# **M42 Junction 6 Development Consent Order Scheme Number TR010027**

## **8.100 Applicant's Comments on any Additional Information or Submissions Received by Deadline 9**

**Applicant's Comments on any Additional Information or Submissions  
Received by Deadline 9**

Drawing file: TR010027 / TR010027-000164-TR010027_M42J6_6-2_Environmental_Statement_Figures_Figure 4.5.pdf

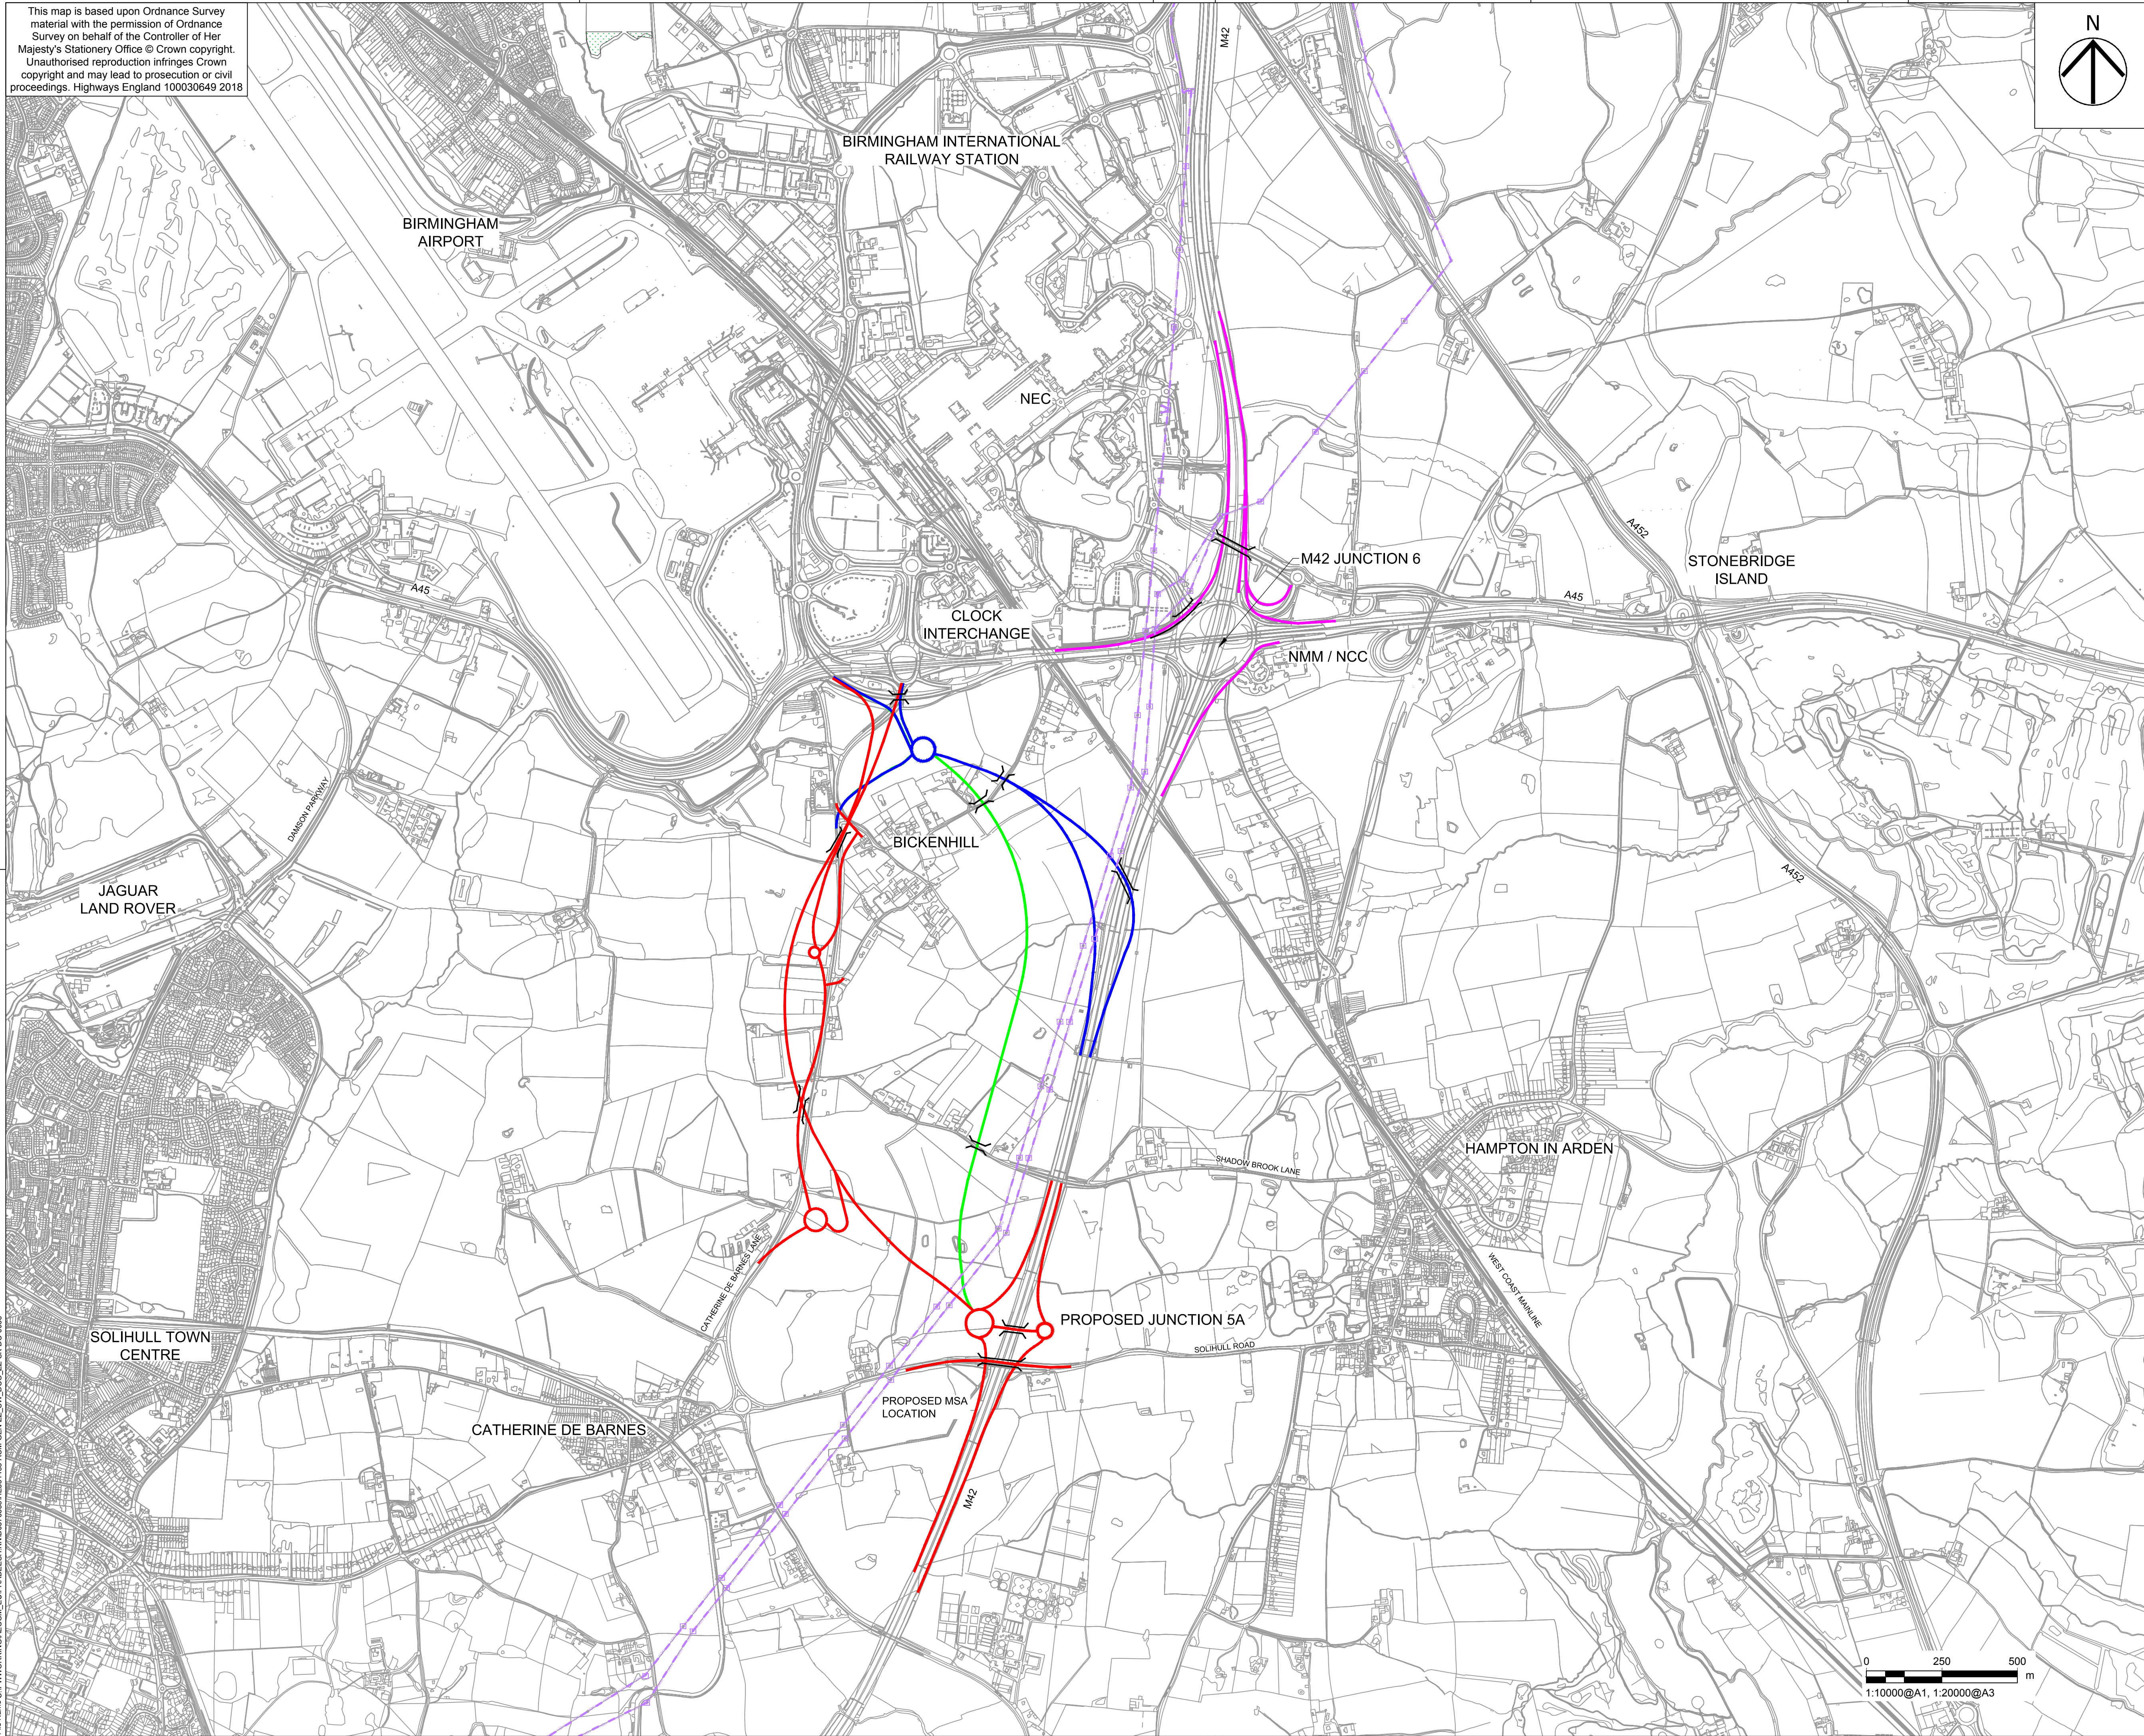
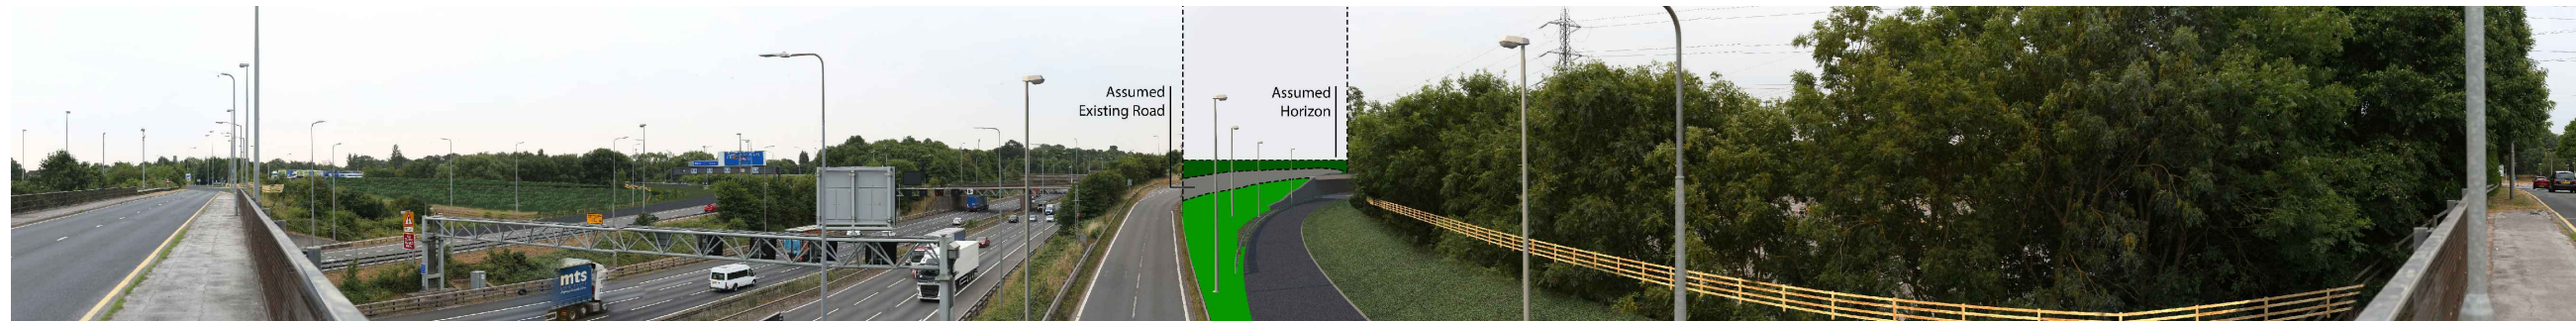
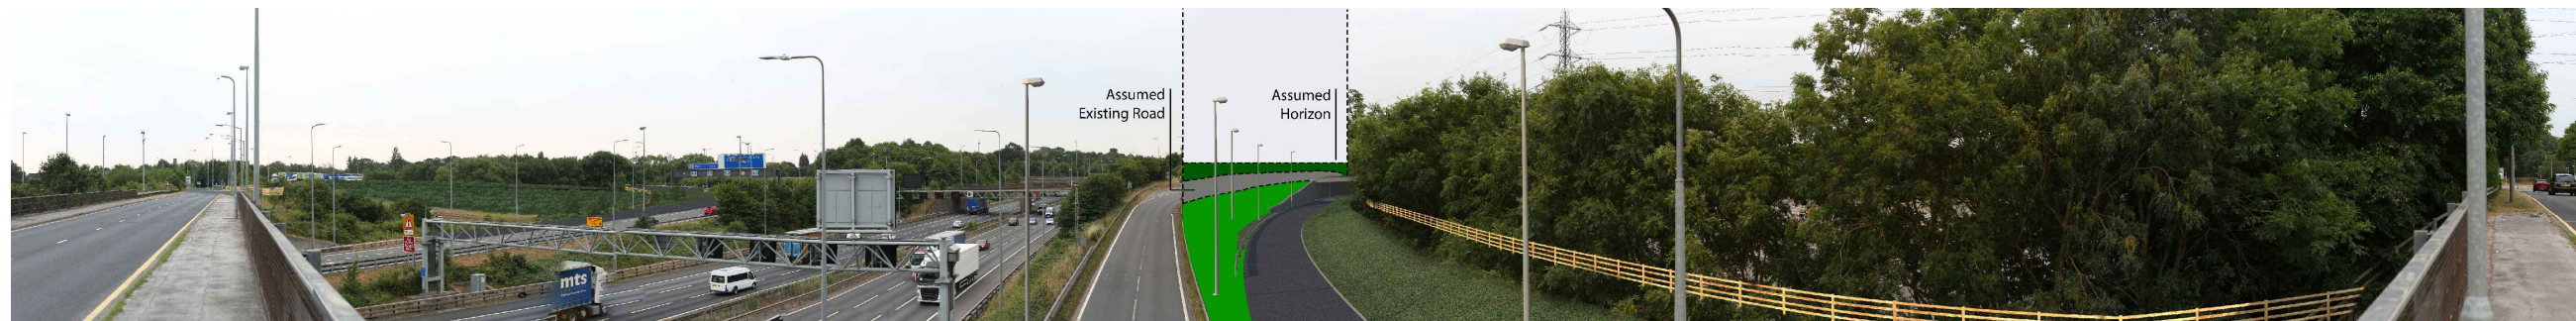
Submitted by	Title	Comments	
Philip O'Reilly	Responses to any Further Information Requested by the Panel	4.3	<p><b>Philip O'Reilly comment:</b></p> <p>The views from my property to the north-east, the east and the south-east will be dominated by the proposed Mainline link road, the proposed realigned Catherine de Barnes Lane, the proposed overbridge, the proposed 'Barber's Coppice Roundabout' and the proposed Merge Slip from 'Barber's Coppice Roundabout' to the proposed Mainline link. However, HE did not think a visualisation of the landscape and visual impact on my property would be representative "to illustrate how the Scheme would likely appear in close proximity, mid-distant and long-distance views across the study area". Instead HE have provided a visualisation from viewpoint R, which shows a close-proximity view of the lower edge of the 'Catherine de Barnes South Overbridge'; a view that does not show how the overbridge sits within the landscape.</p> <ul style="list-style-type: none"> <li>• It is beyond belief that none of the viewpoints HE have chosen as "representative" include a visualisation of 'Barber's Coppice Roundabout' and the surrounding area.</li> </ul> <p><b>The Applicant response:</b></p> <p>Visualisation locations are chosen to be representative and proportional to the assessment of a proposed scheme and to illustrate how the Scheme would likely appear in close proximity, mid-distant and long-distance views across the study area. These are agreed with SMBC. A visualization at viewpoint EE would not provide any further understanding of the impact of the Scheme in this location, as the landscape assessment as presented within Chapter 8 [APP-053/Volume 6.1] of the Environmental Statement already states a large adverse effect at this viewpoint would occur.</p>

**OPTION 1: INDICATIVE ALT. ARRANGEMENT TO REDUCE IMPACT ON CHURCH FARM LAND**

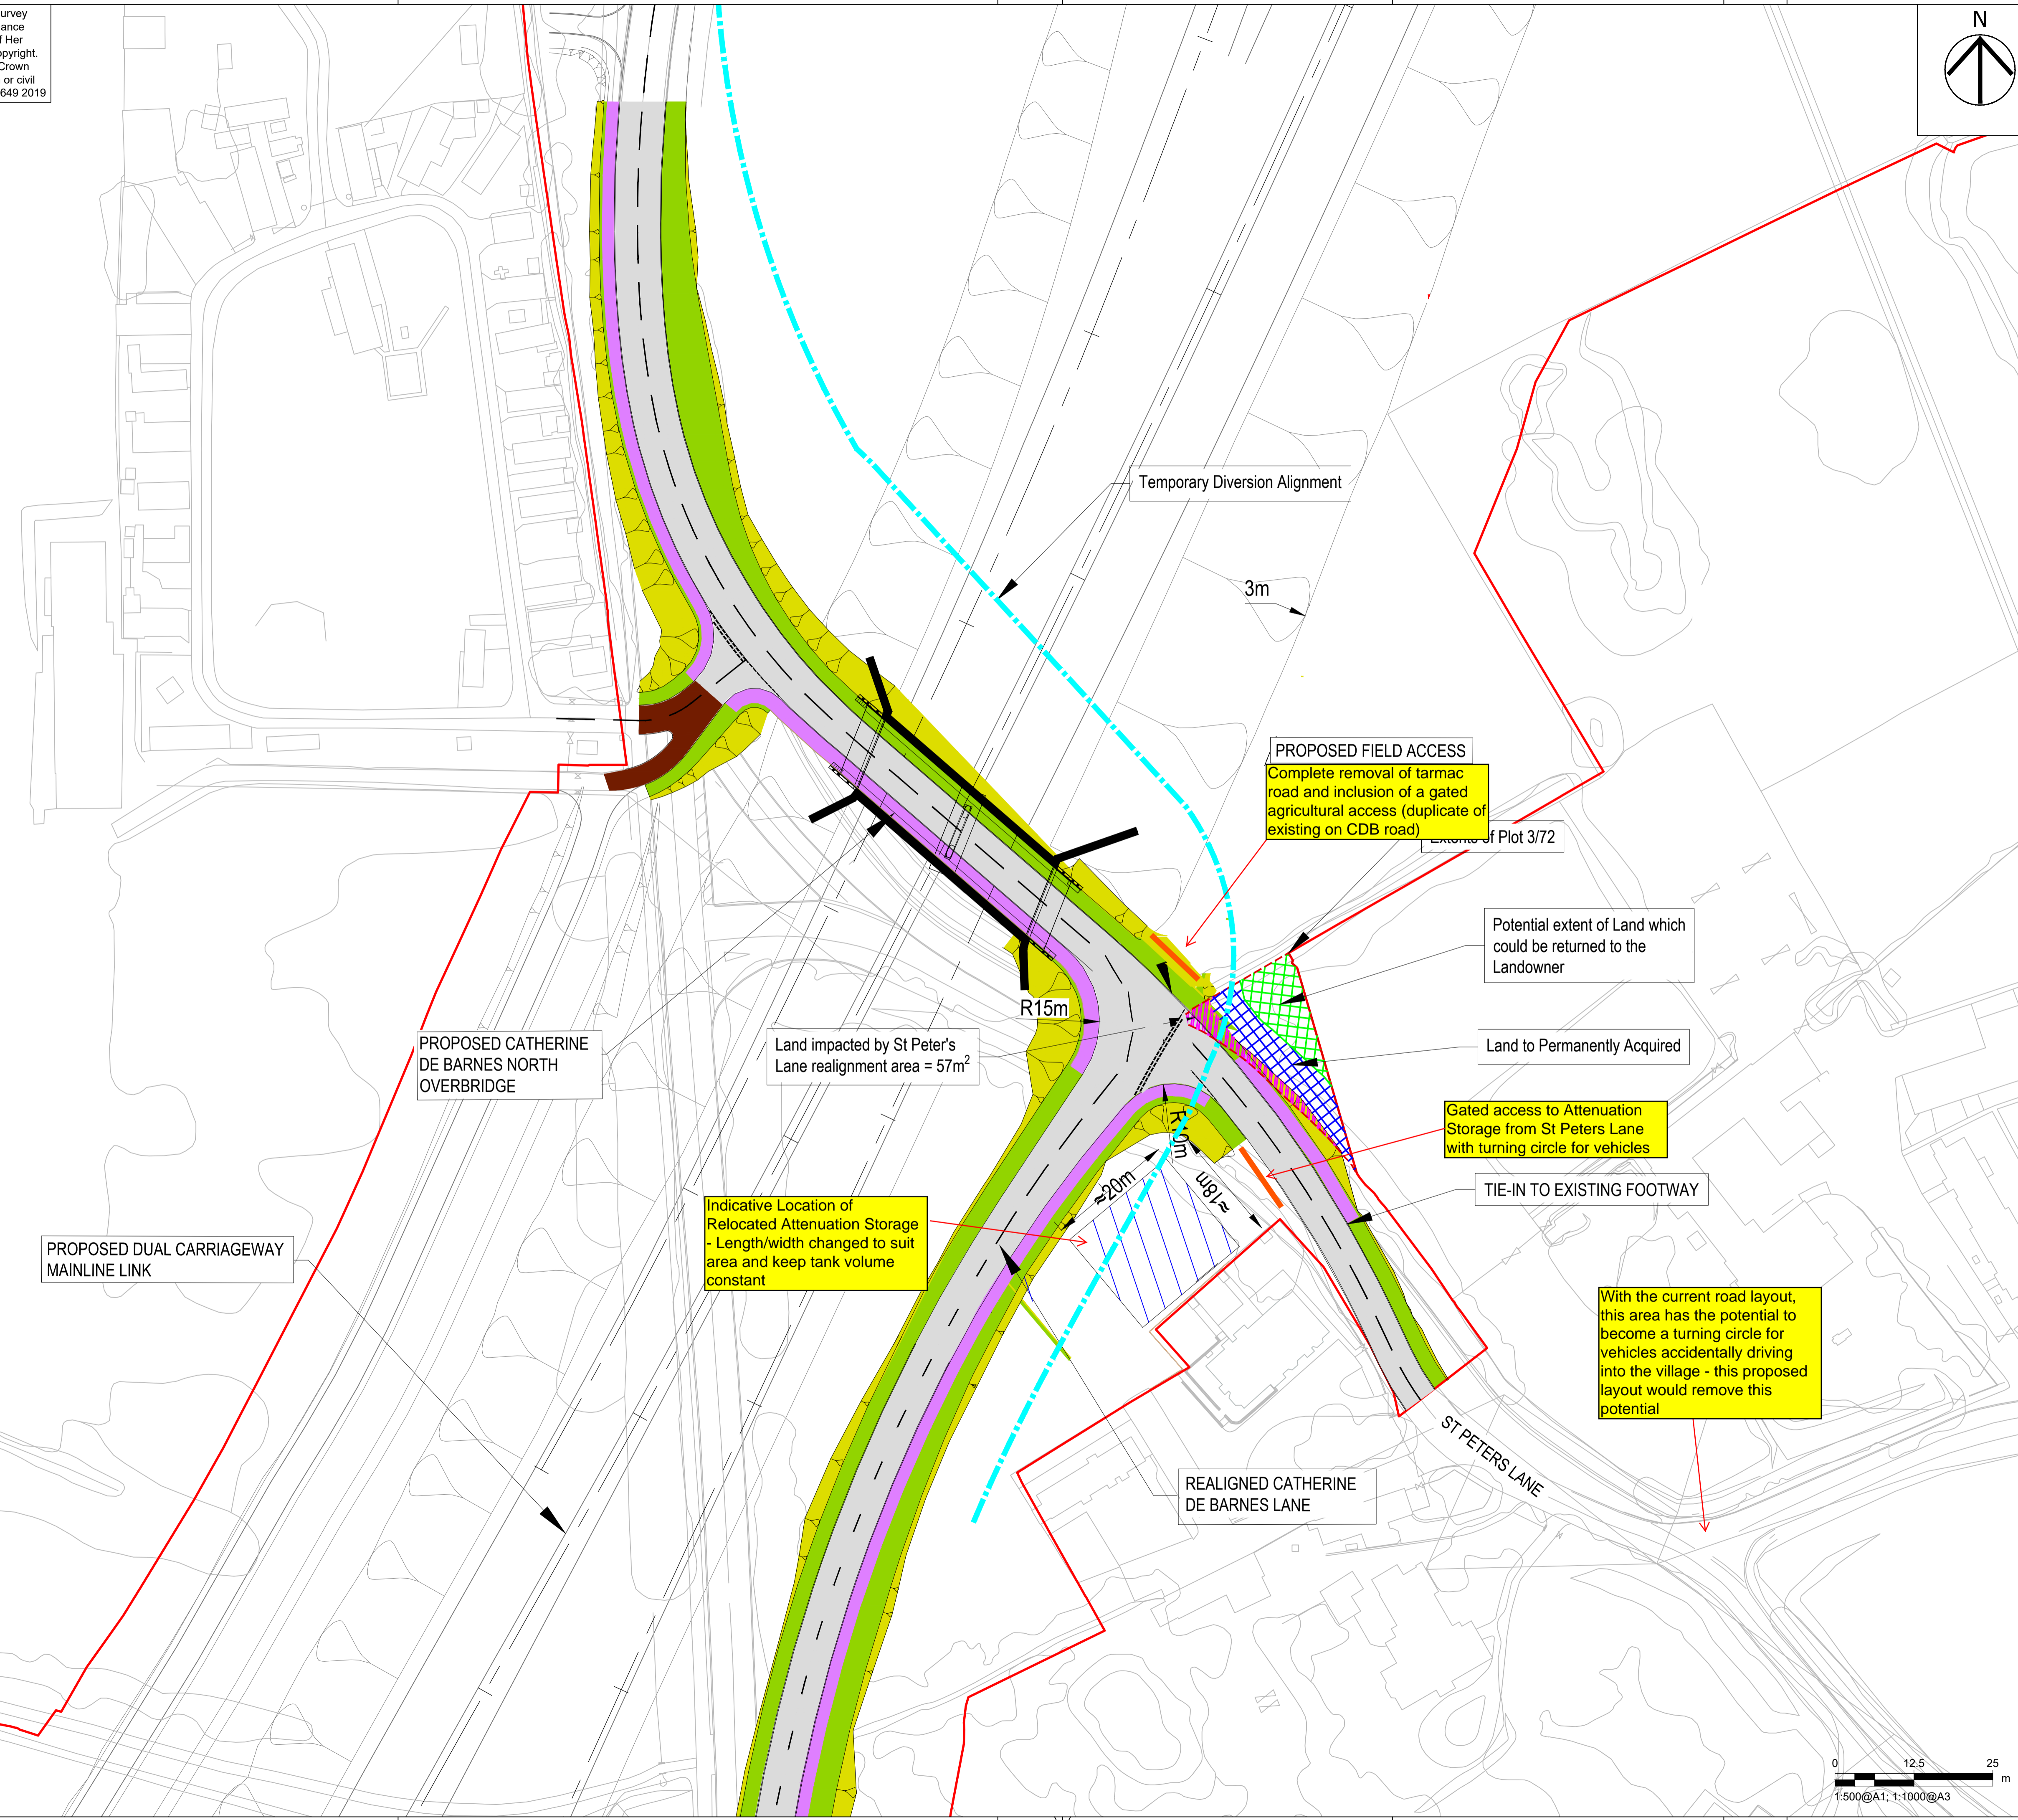
Submitted by	Title	Comments	
Open Spaces Society	Additional representation responding to Highways England Submission on Actions Arising from hearing on 1 October 2019	Part 4	<p><b>Open Spaces Society comment:</b></p> <p>The applicant has now produced a detailed plan and section of the area where an overbridge with a supporting column could be provided. With regard to the Airport Safety Zone, there appears to be something of a dual standard being applied. The existing ground level is depicted as already infringing the Zone by about 8 m. This implies a small, but recognised, risk that an aircraft deviating from the normal path could contact the ground. The disaster at Kegworth , 30 years ago, shows the potentially catastrophic effect of an abrupt change of ground profile. It is appears unlikely a footbridge within the cutting would cause a significant increase in the risk. As a three-dimensional design problem, the constraints have been set out, but no options have been worked through to the stage that the proposed bridge should be dismissed.</p> <p><b>The Applicant response:</b></p> <p>As part of the Actions Arising out of ISH on Living Conditions on 1 October 2019 for Deadline 7 [REP7-011/Volume 8.86], the Applicant set out the constraints that need to be considered if a pedestrian footbridge were to be installed to serve Public Right of Way M112. Based upon these assessments, it was concluded that a footbridge could not be implemented without either compromising Birmingham Airport's Safeguarding Zones, requiring departures from standard on the mainline dual carriageway link road or alternatively implementing a material change to the draft Development Consent Order. As a consequence, the Applicant remains of the view that the alternative route provided in this application is, on balance, the most appropriate solution having been developed in consultation with Solihull Metropolitan Borough Council.</p>
